WEST SUSSEX COUNTY COUNCIL

SUBJECT: LU/257/08 - COU from offices to ground floor restaurant and first and second floor flats

26, High Street, Littlehampton, West Sussex

RECOMMENDATION:

PROPOSED GROUND FLOOR PLAN

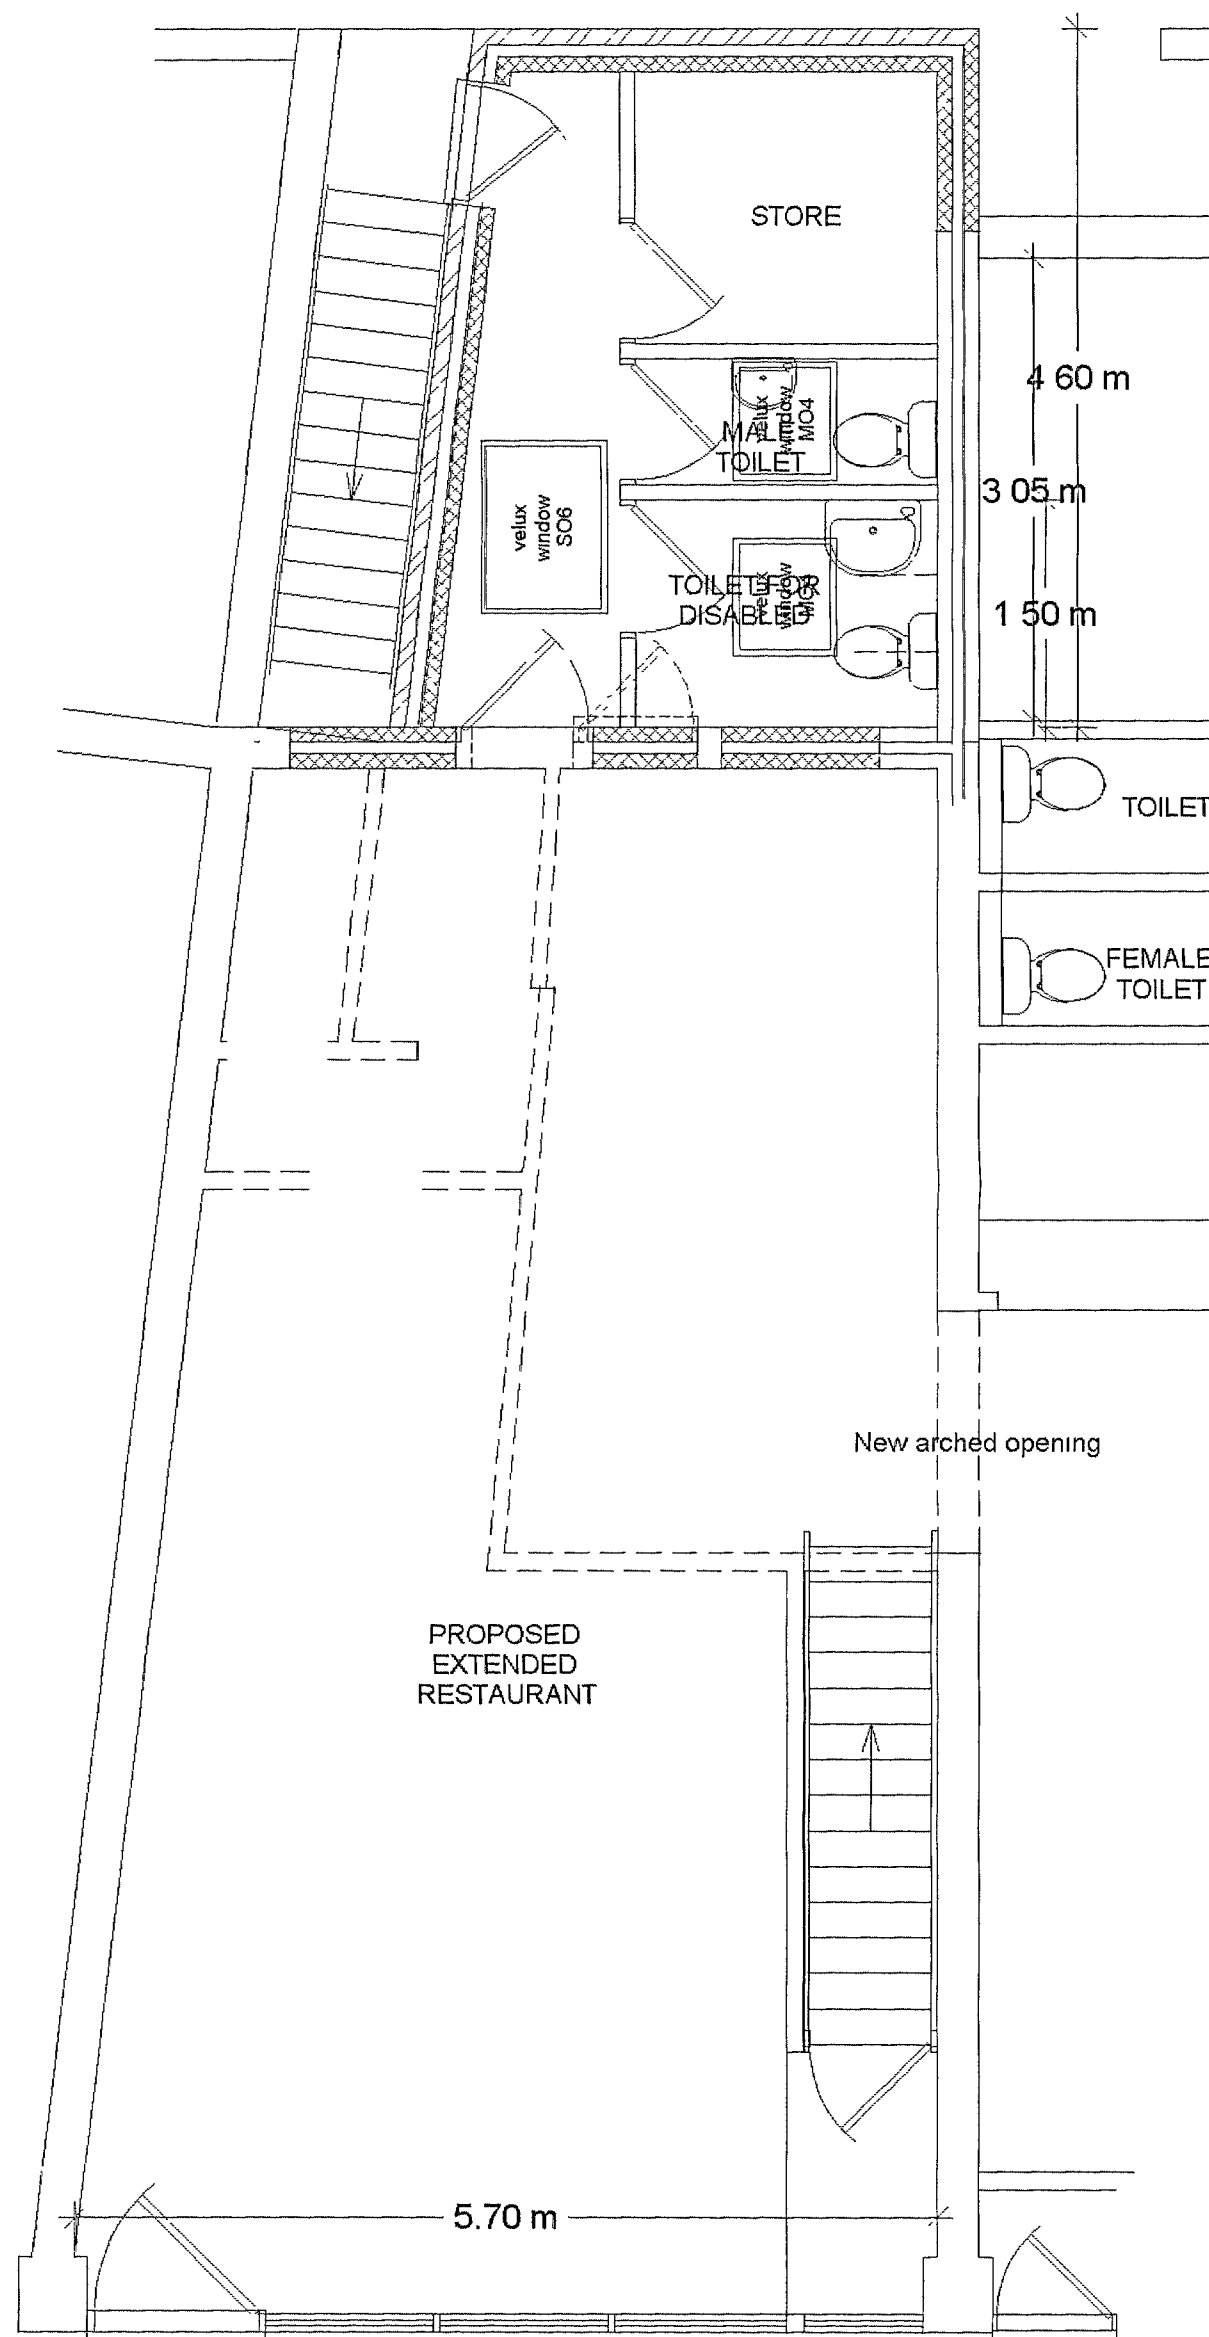
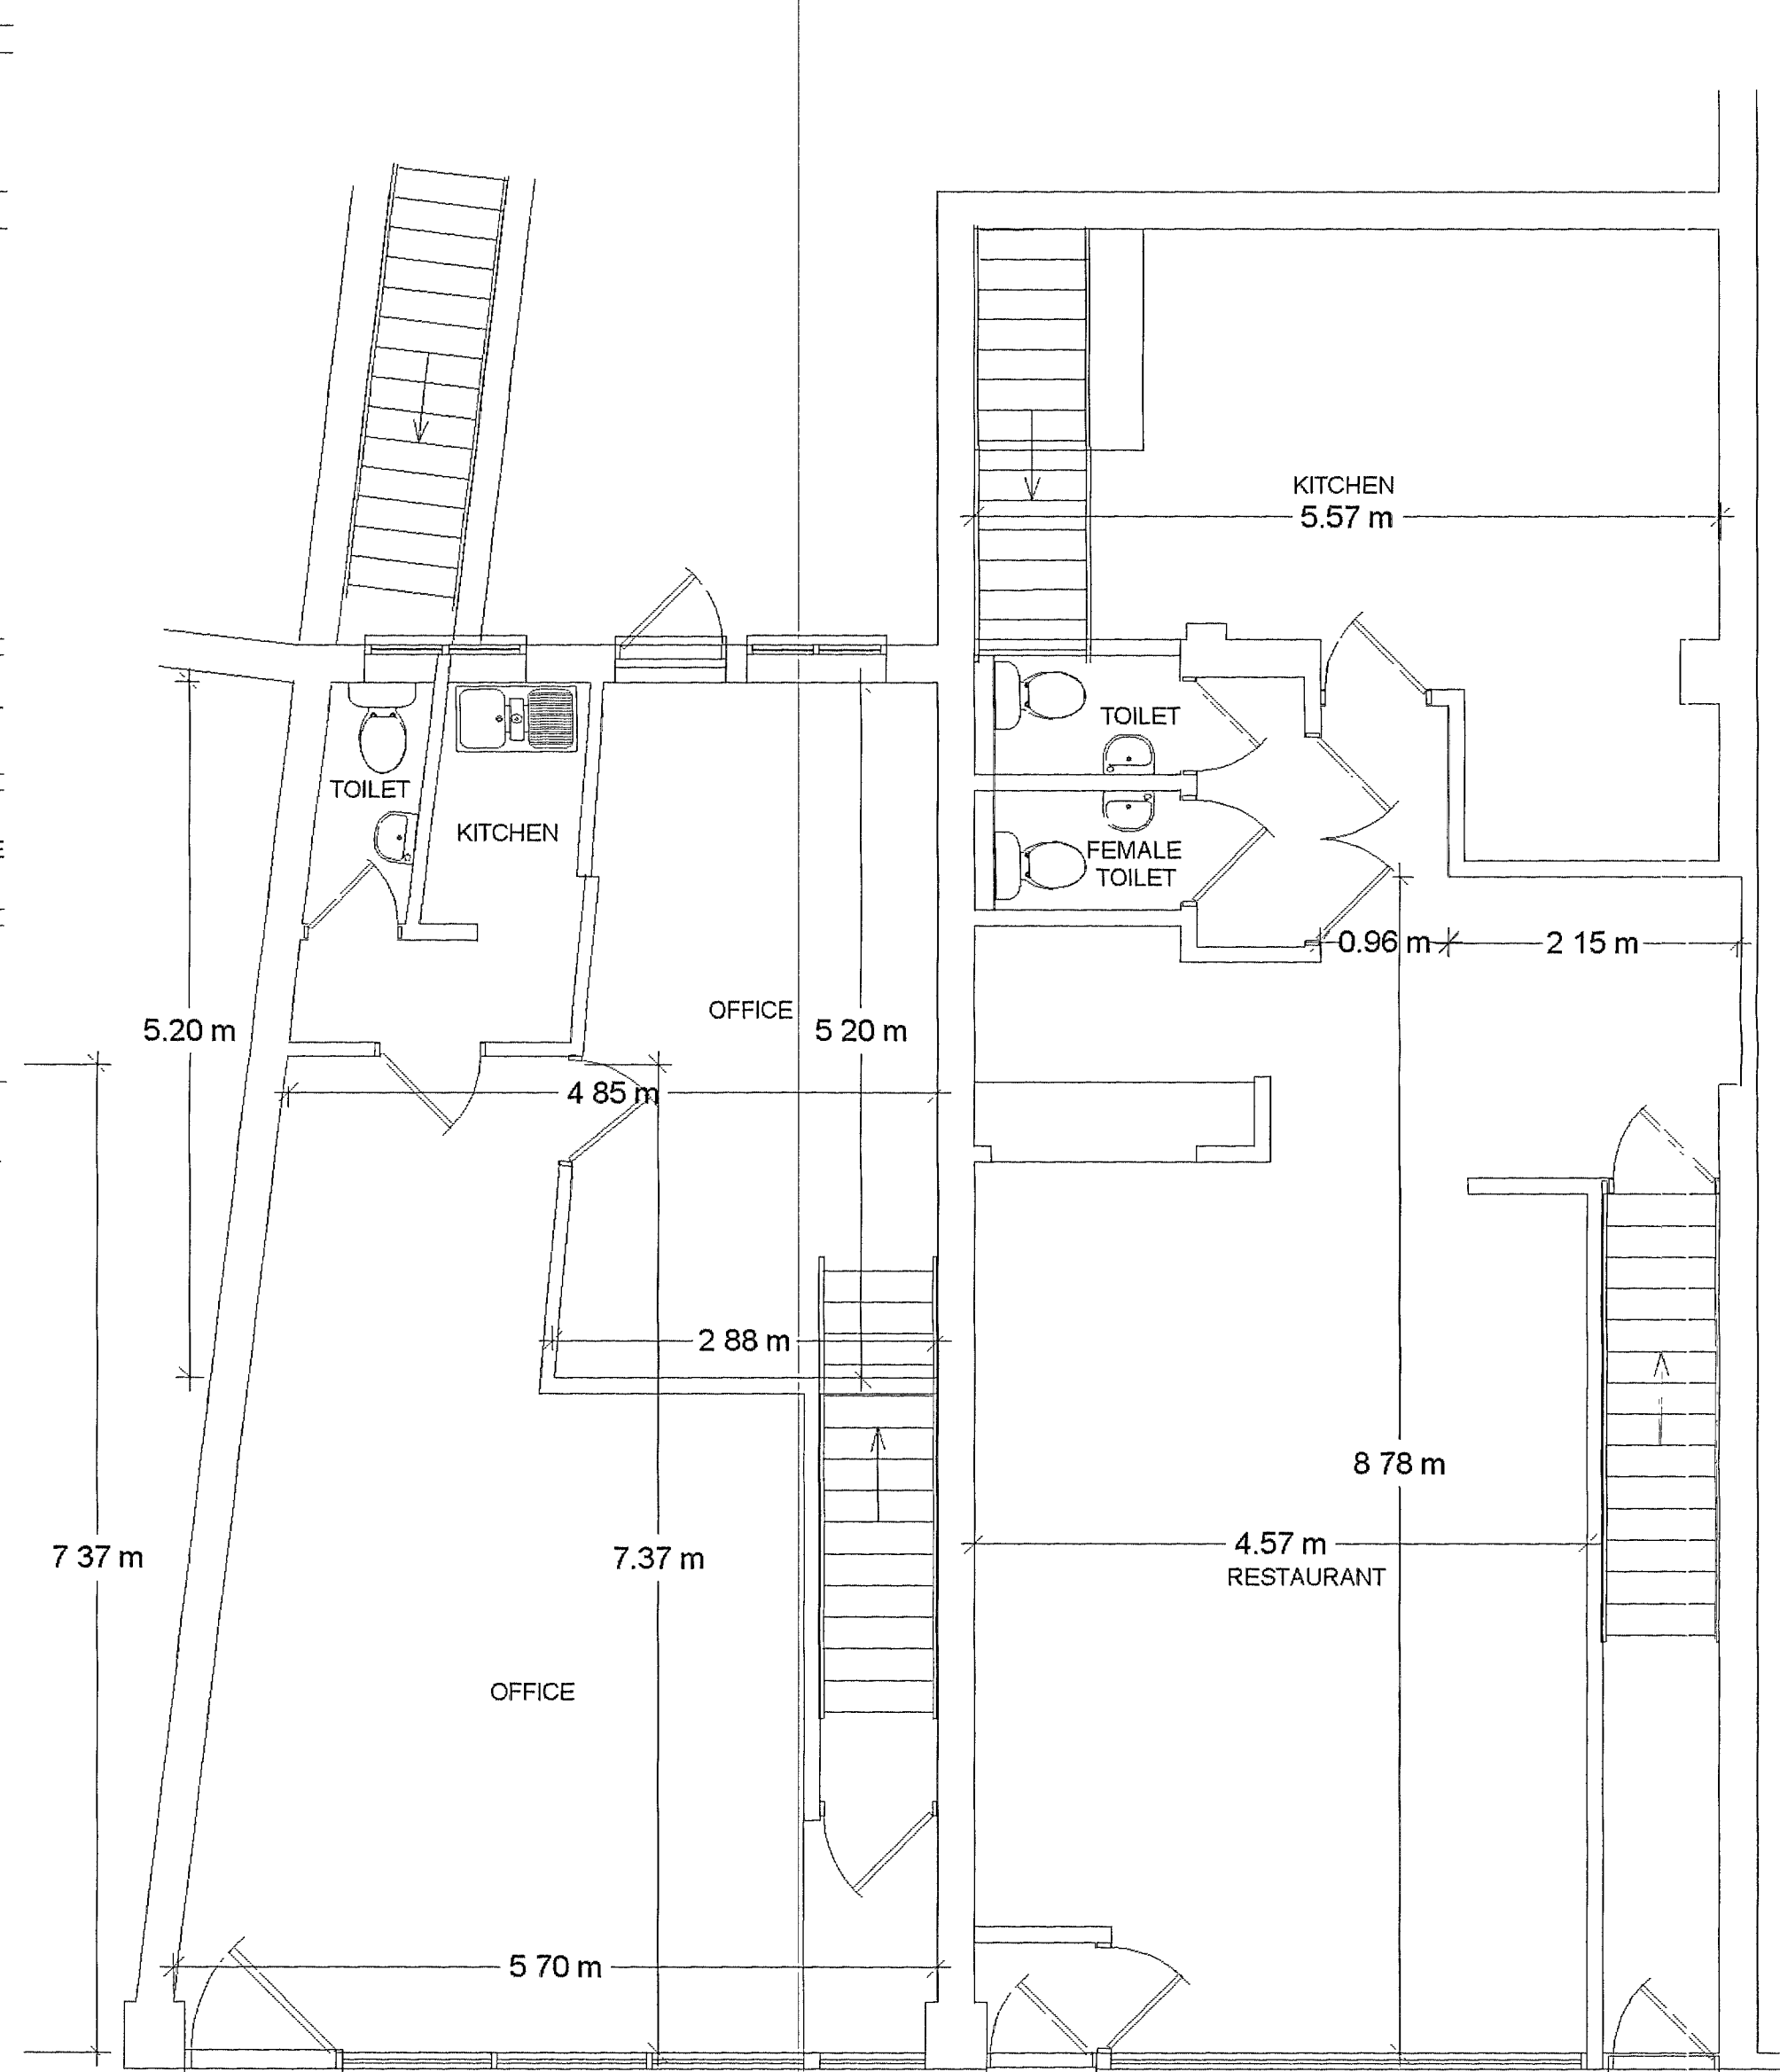
There would be a requirement for the development proposals to include an element of cycle parking in accordance with WSCC minimum standards.
